East Anglia TWO Offshore Wind Farm

**Natural England's Comments on Offshore Ornithology Without Prejudice
Compensation Measures v2 [REP8-089]**

Planning Inspectorate Reference: EN010078

15th April 2021

Figure 10.2 Vessel routing measures for East Anglia ONE North and East Anglia TWO

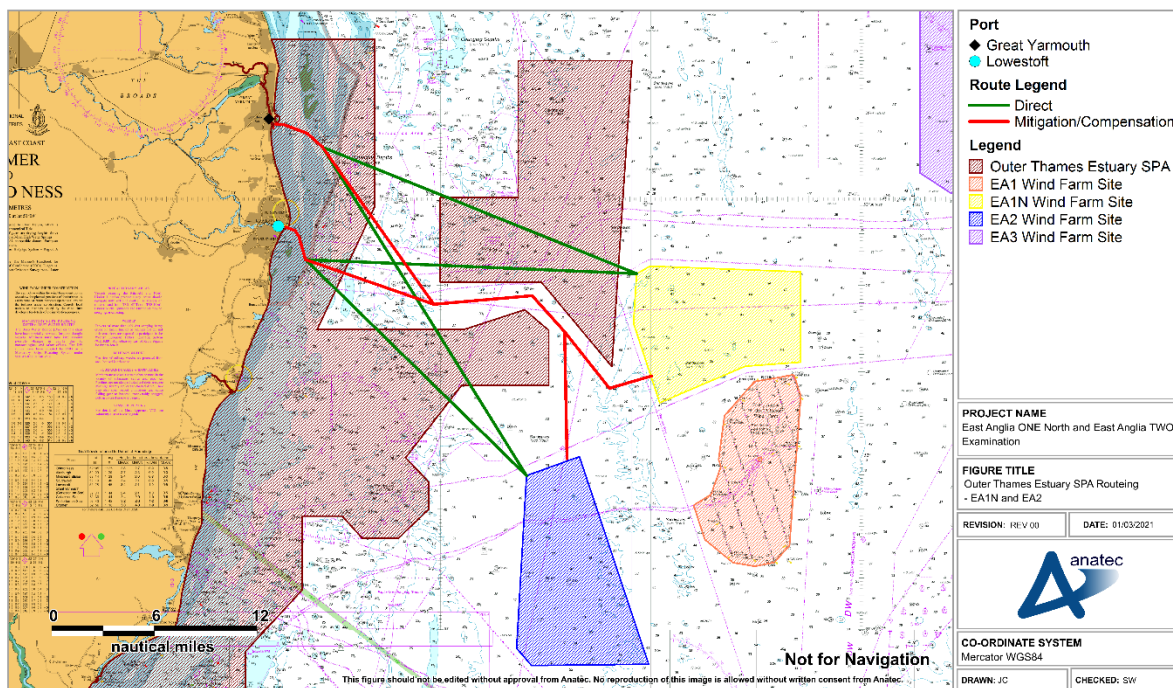
Natural England continues to advise that the proposed measure of vessel navigation management will not provide compensation that addresses the AEOI on the Outer Thames Estuary as a result of effective loss of habitat, and the change in distribution, as a result of displacement from the presence of turbines. We do acknowledge the benefits of the proposal in mitigating for the disturbance caused by vessel movements, however this does not represent compensation. As regards vessel navigation from East Anglia 3, given the mitigation measures in place for that project, vessel movements were not considered to

represent an AEOI on the OTE SPA during the determination of that project: it is hard therefore to see how removing a sub-AEOI impact could provide sufficient compensation for an AEOI.
